City of Albuquerque Stormwater Construction Site Inspection Report

General Information					
ESC File No.	A11E018	Project Name:	Take Five Oil Change		
NPDES Id. No.	NMR1007LC	Location:	10830 Unser Blvd NW		
2/17/2026	Owner	Contractor			
Operator	Albuquerque-Unser Take Five, LLC	White Sands Construction, Inc.			
Contact name & title	Glen Cherry	McChristie Curry			
e-mail	glen.cherry@durbangroup.com	kimber@whitesandsconstruction.com			
Contact Phone #	704-319-8337	857-437-7816			
COA Inspector	Chancellor English	Start/End Time:	2:30pm		
Construction Phase:	Verticals				
Type of Inspection:	Regular	Storm Event	Post Storm Event >0.25"	311/Complaint	Follow Up
Weather at time of inspection?	Windy		Temperature: ~	55	
Estimated date of last storm 0.25" or greater	1/8/2026

TAKE 5 OIL CHANGE ALBUQUERQUE, N.M.	DRAWN BY LN
	ESC PLAN	DATE 11/25/2025
	TIERRA WEST, LLC 5571 MIDWAY PARK PLACE NE ALBUQUERQUE, NM 87109 (505) 858-3100 www.tierrawestllc.com	2023042_SWPPP
11/25/2025 RONALD R. BOHANNAN P.E. #7868	C7.1	SHEET # C7.1
		JOB # 2022007

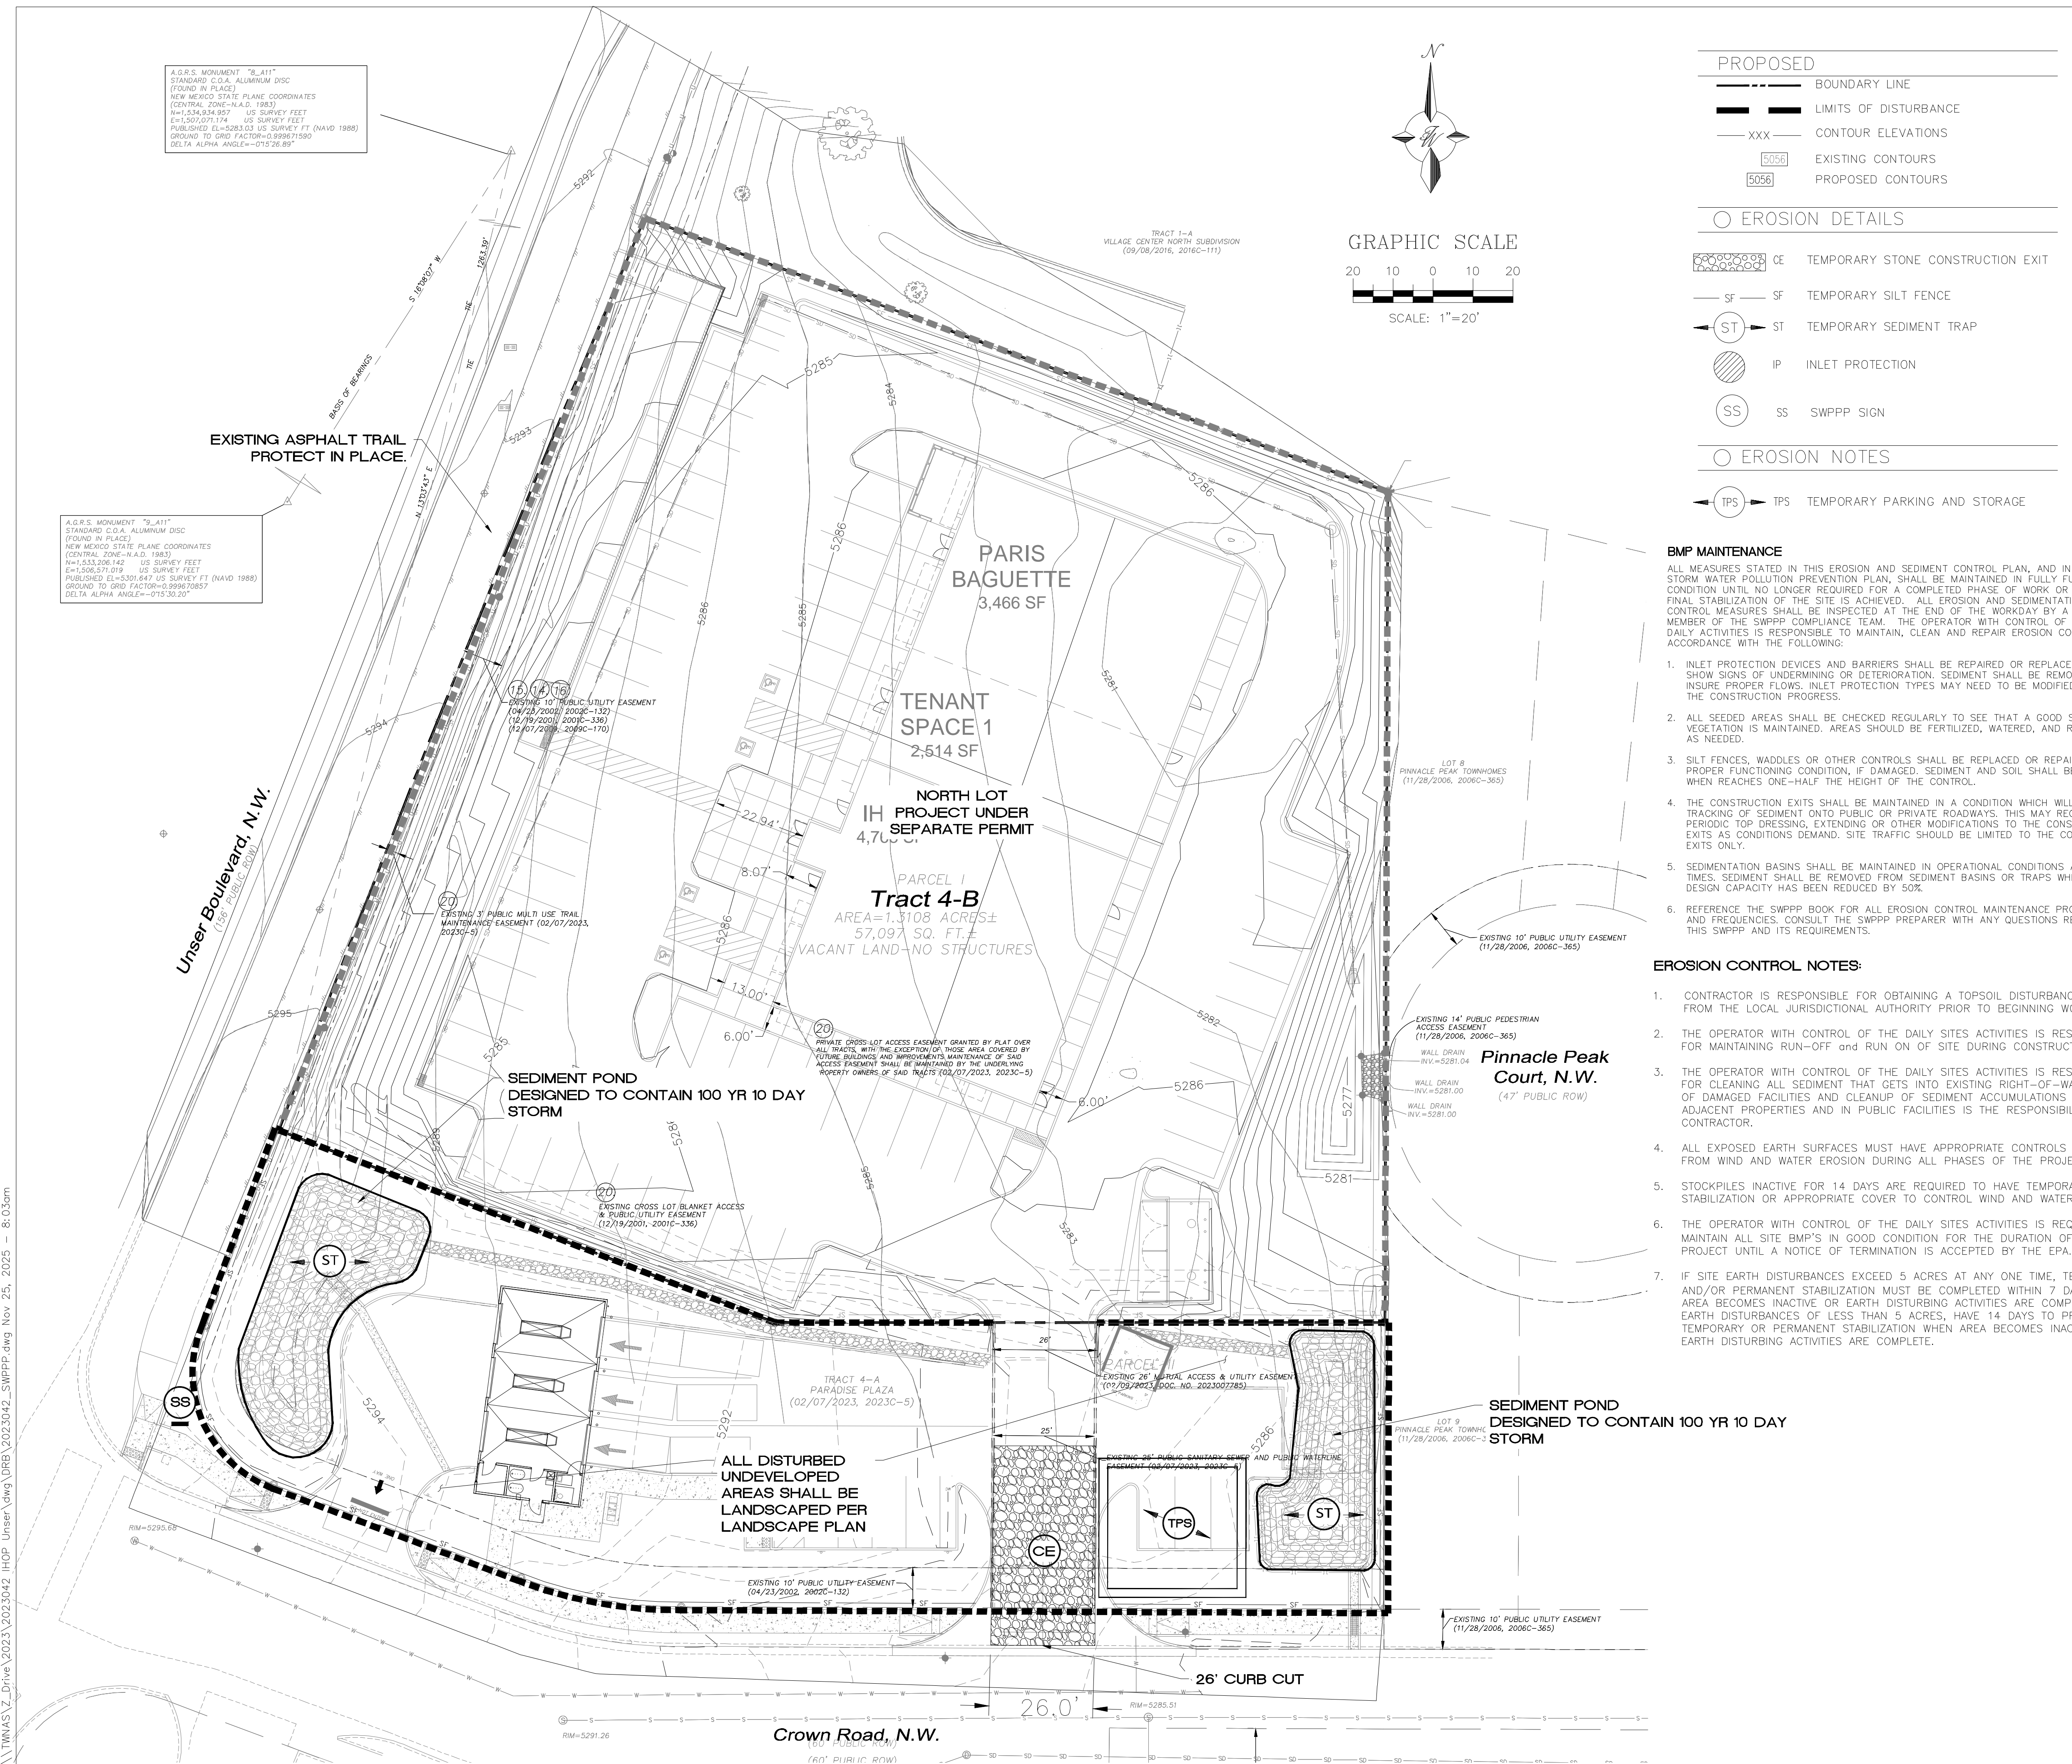
Item Number	Deficiency/ Corrective Action				
1	SWPPP - There are several violations related to the inspection reports. There was no date of inspection on the reports in violation of CGP Part 4.7.1. The inspection reports are missing the owner's signature in violation of CGP Part 4.7.2. There is no training certificate in the SWPPP for the inspector on the reports in violation of CGP Parts 6.3 and 7.2.2. Required mitigation: Each inspection report must include the inspection date per CGP Part 4.7.1.a. Each inspection report must be signed by the operator's signatory in accordance with CGP Appendix G, Part G.11 per CGP Part 4.7.2. The EPA does not allow a Delegation of Authority to a third party. The delegated authority must be part of Albuquerque-Unser Take Five, LLC, not White Sands Construction. Include documentation in your SWPPP that members of the stormwater team responsible for conducting inspections pursuant to Part 4 (Inspections) have received the training required by CGP Part 6.3 (Training Requirements for Persons Conducting Inspections).
